Application for a non-material amendment following a grant of planning permission.

New dwelling & separate garage replacing the proposed new house in the previous planning permission ref: M/7/16/PL - Amendment to M/153/18/PL

Reference number:	M/32/19/PL
Date of decision	08/01/2020

Comprising changes of chimney stack locations & fenestration to the ground floor.

Drawn by:	Date:	Scale:
GW	JUNE-20	As stated
Drawing/Cad Ref. No.:	20-189	
Drawing No.:	20-189-20	Rev: A

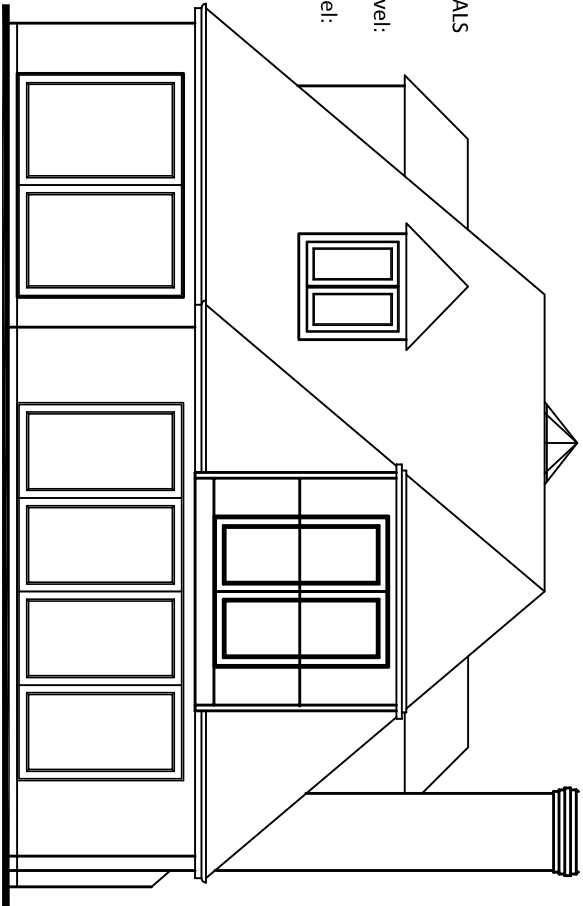
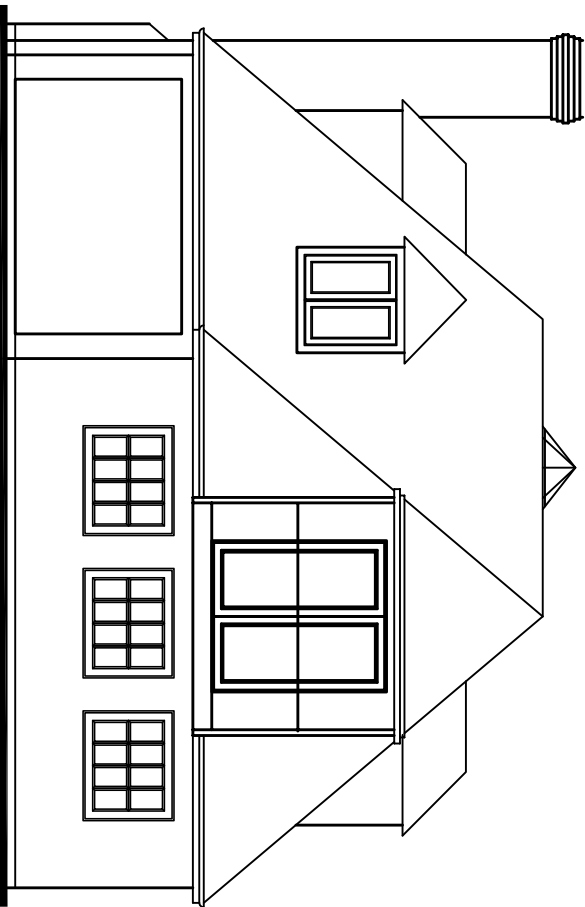
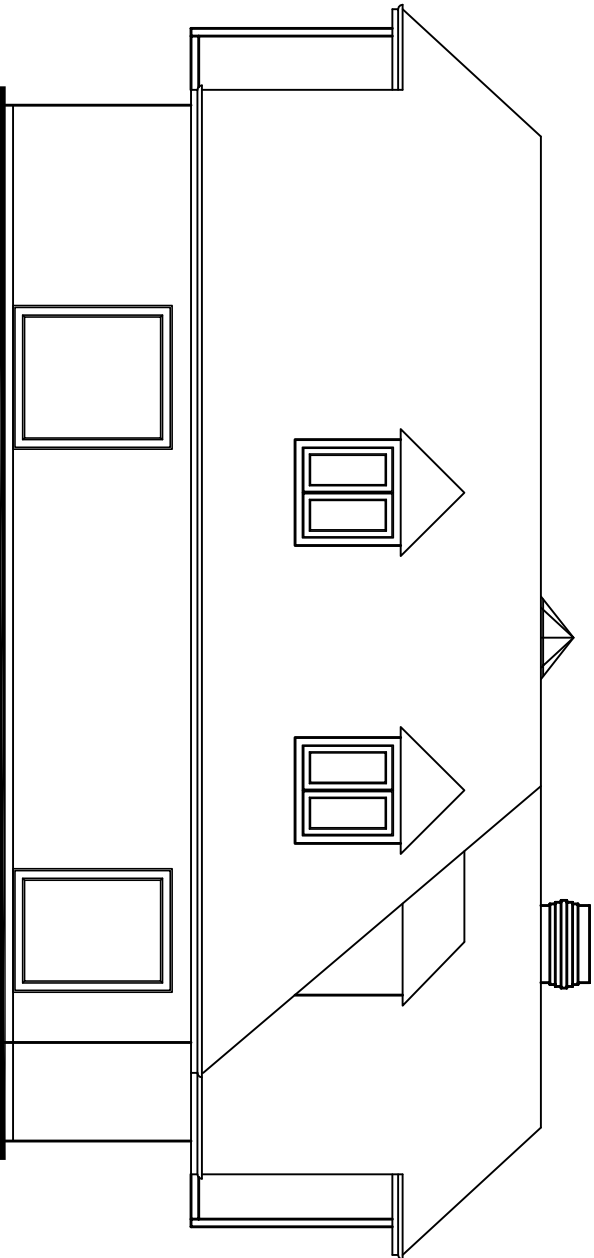
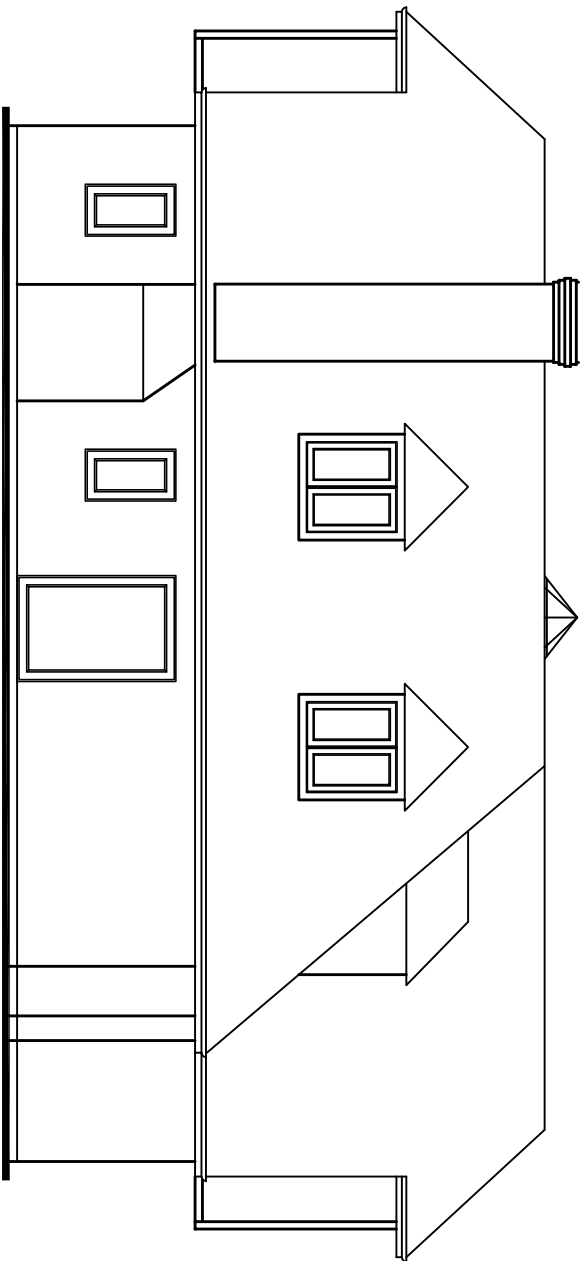
Reconfiguration of chimney flue forming resulting in one stack i.e. removal of one stack - adjustment of fenestration to provide symmetry.
